December 16, 1983
AL-801-231-50

RE: ADDITIONAL INFORMATION FOR DRAINAGE PLAN
SUNWEST OPERATIONS CENTER ANNEX, 515 SLATE AVE., N.W., J-14-Z

As you requested in our conversation of December 14, 1983, we have added the following information to the above-referenced Drainage Plan dated November 29, 1983. A print of the revised Site Plan and Drainage Plan is attached.

REV. DEC 16, 1983  
 PLATE I

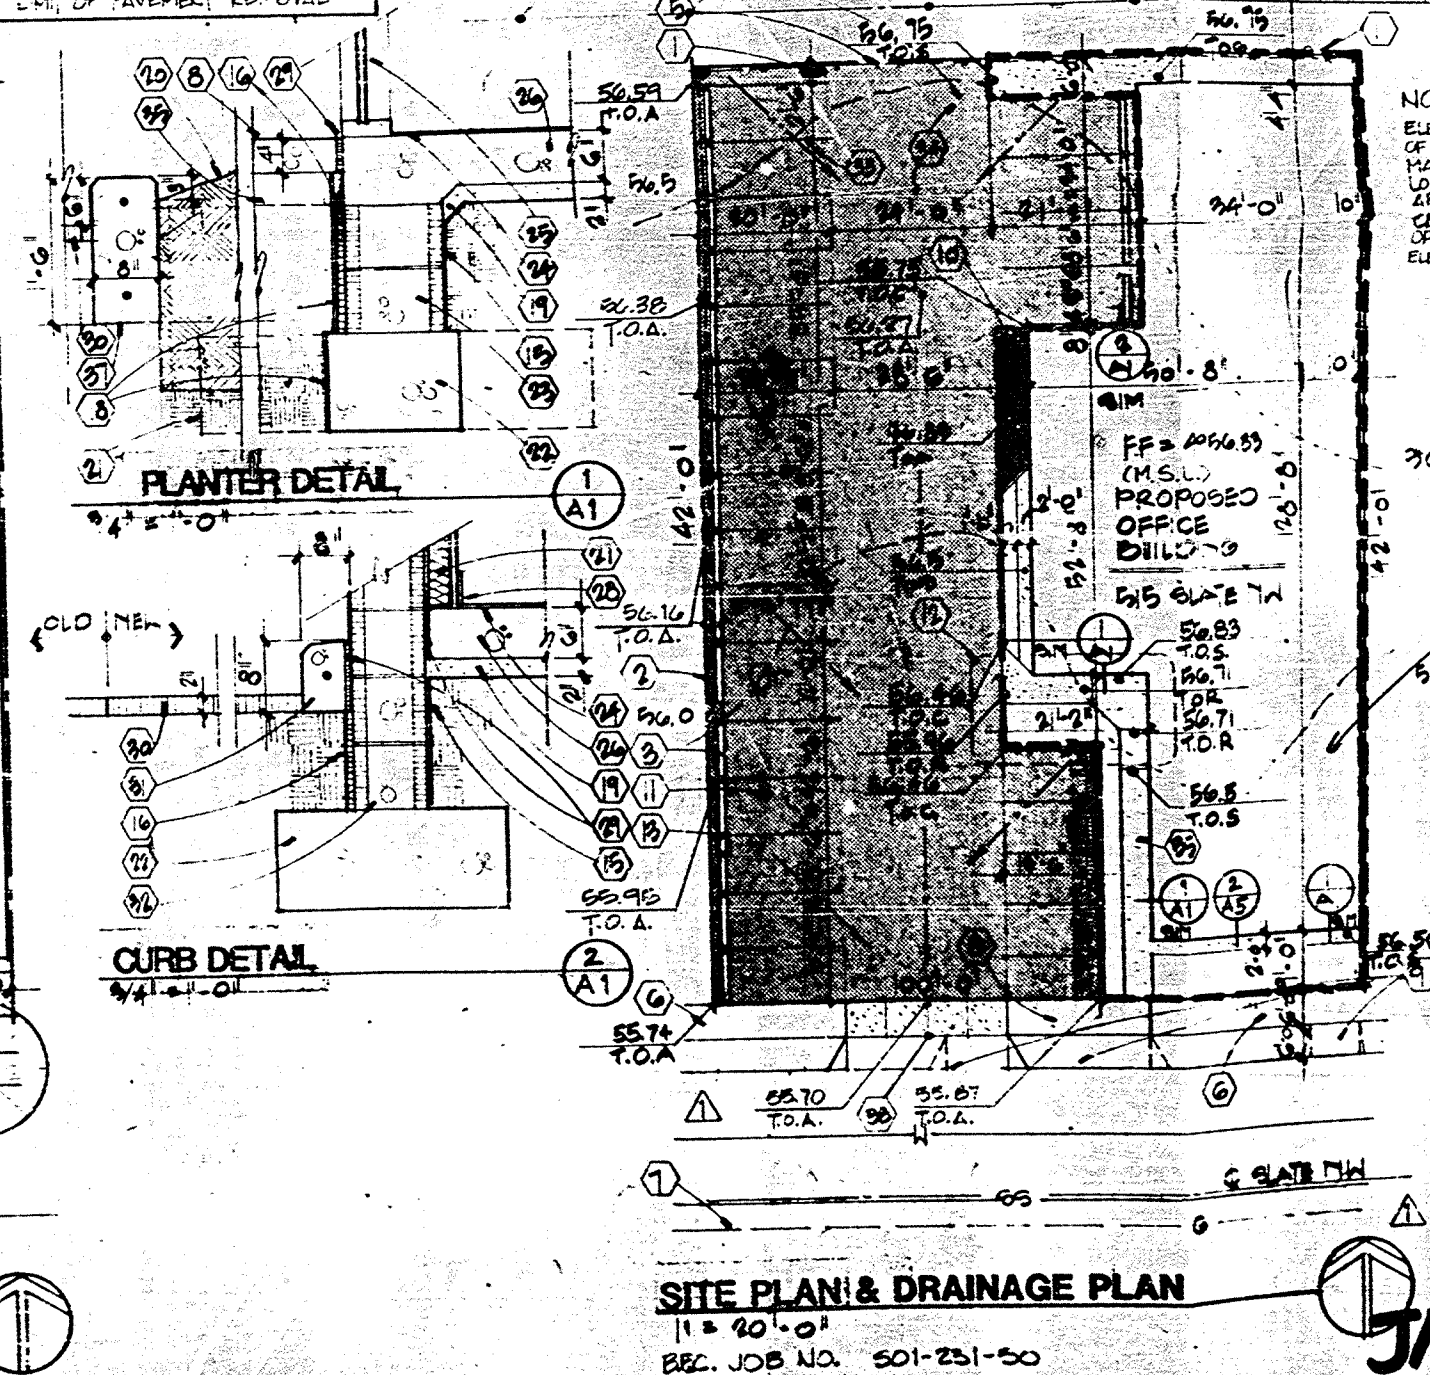
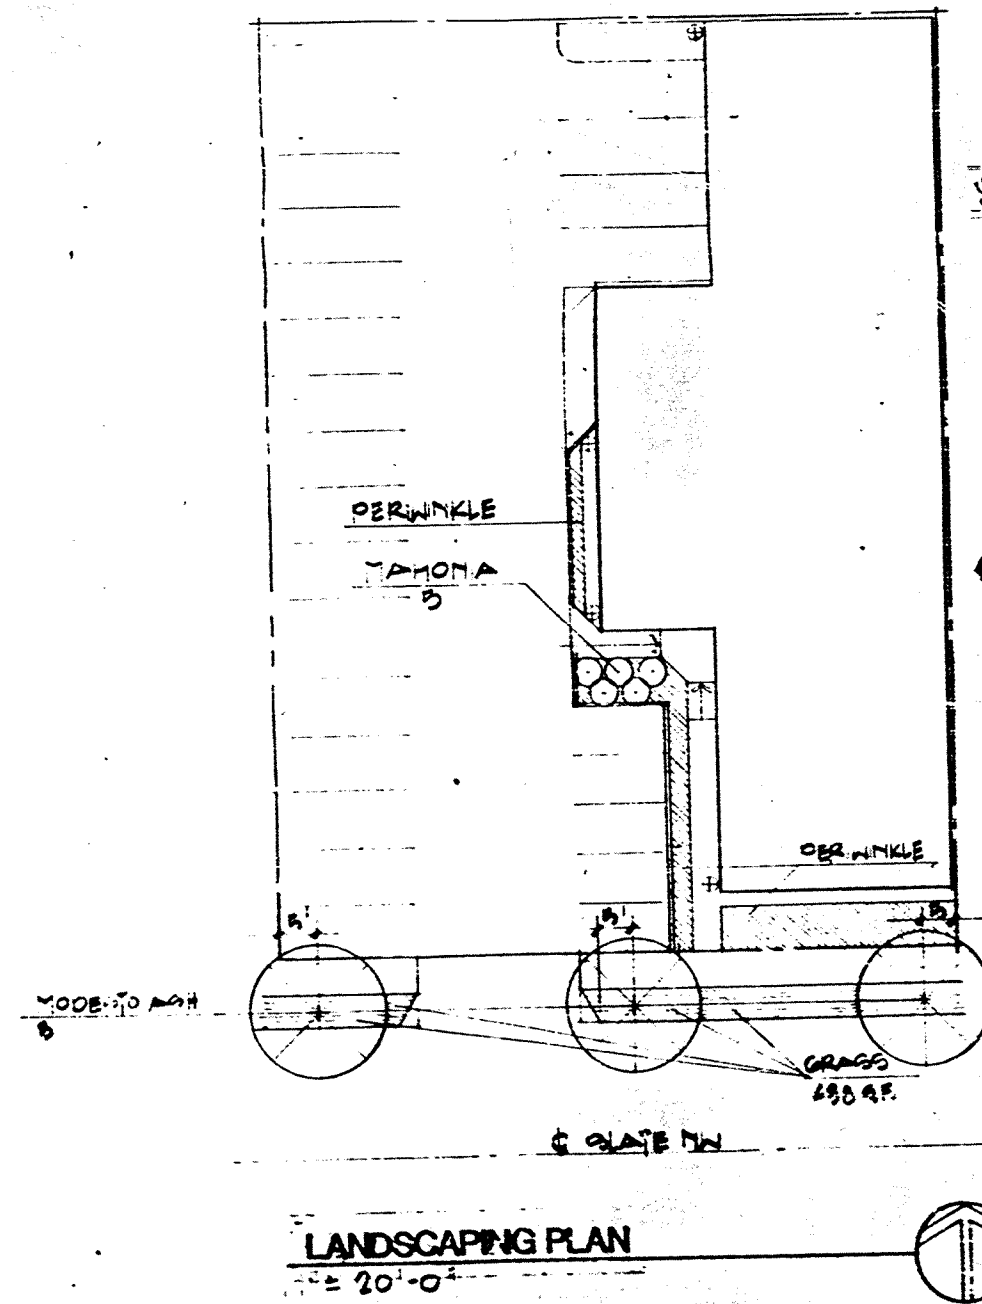
1. Additional spot elevations on the top of asphalt in the existing paved parking area and driveway to supplement the contour elevations already shown.
2. Arrows indicating direction of flow of storm runoff.
3. Limit of pavement removal to clarify keyed Note 11.
